Subdivision Comments

Date: 08/07/2020

RE: SP-20-00005

ZIPPERER SHORT PLAT, SP-20-XXXX

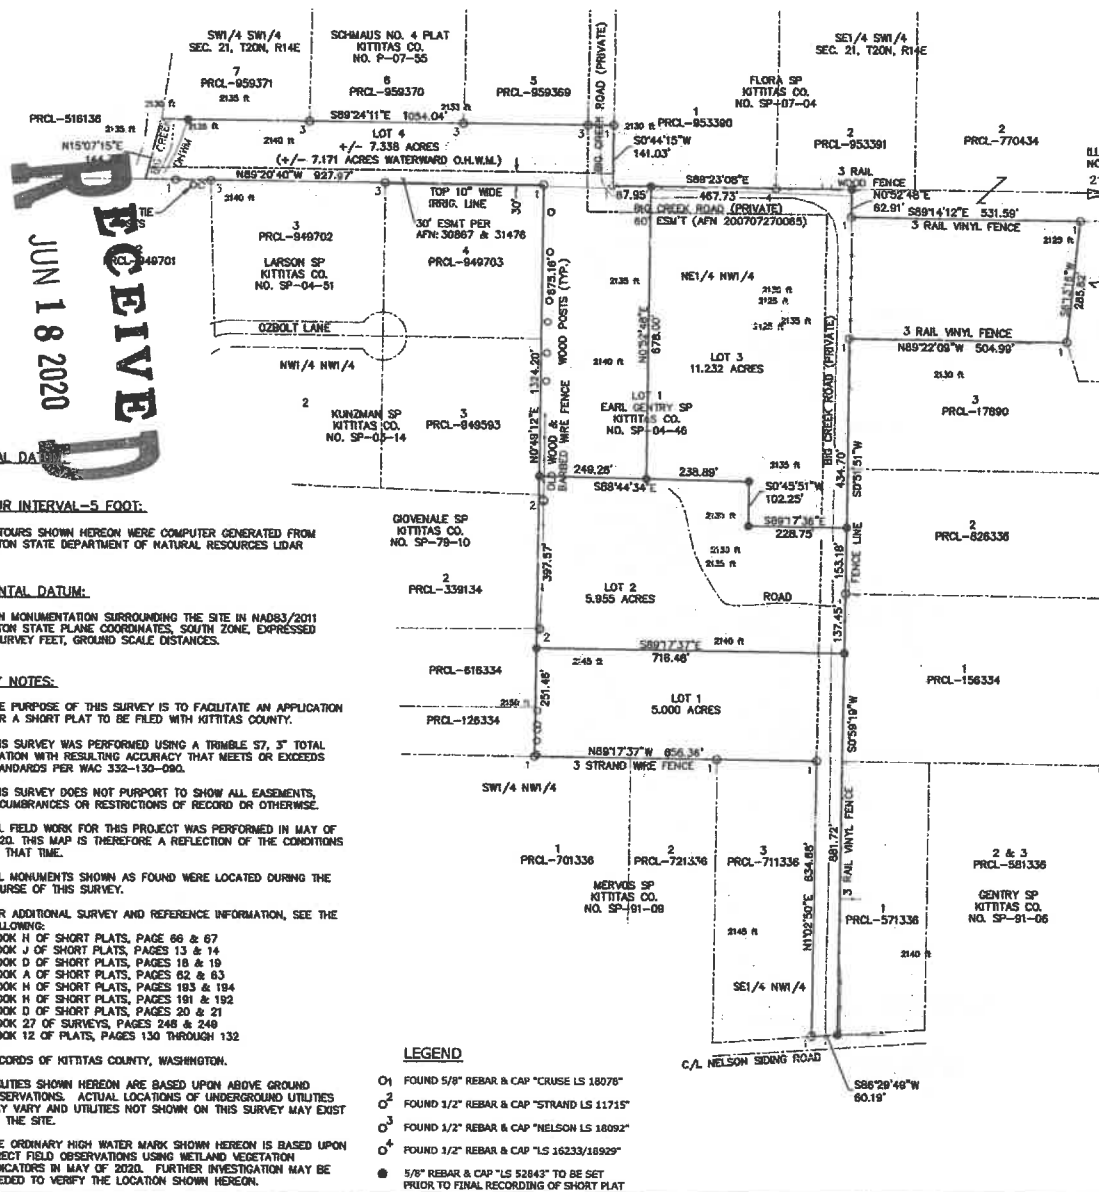
Any On-Site Septic systems that are to be utilized for wastewater management must adhere to the standards set by both the Washington Administrative Code, and Kittitas County Code. In accordance with KCC 13.04.090, a minimum of one soil log for each proposed lot where individual sewage disposal systems are contemplated must be completed (see **Condition B-3**). Public Health requests clarification on the on-site sewage disposal system plan.

Proposed short plat indicates individual and shared wells will be used. If the intention is to utilize a shared well, a signed, notarized, and filed shared well users agreement will also need to be provided before the short plat is finalized. If shared wells are to be utilized, the wells must be drilled a minimum of 50 feet from any proposed property line and a signed, notarized and recorded shared waters users' agreement for each shared well must be submitted to our office prior to final plat approval. The applicant must prove legal and physical availability of water for all new uses of water on proposed lots of this project, which can be provided through mitigation certificates (see **Condition B-1**) and a well log or 4 hour draw down test as proof of water adequacy for each new well (see **Condition B-2**). All persons who are making applications for land use including but not limited to short plats must comply with KCC Chapter 13.35.027 per KCC Chapter 13.35.020.

B-2 13.35.020(b) requires proof of adequate water supply, which can be submitted through a well log or 4 hour draw test result. If shared wells are used, a signed, notarized, and recorded shared well-users agreement must be submitted. All individual and shared wells must meet the distance requirement of 50 feet from the property line, 50 feet from the septic tank and 100 feet from

B-3 Soil logs are required for lots. In accordance with KCC 13.04.090, a minimum of one soil log for each proposed lot where individual sewage disposal systems are contemplated must be completed prior to final plat approval. Soil logs can be scheduled at <https://www.co.kittitas.wa.us/health/septic-inspection.aspx>. Soil logs are performed in accordance with Washington Administrative Code 246.272A.
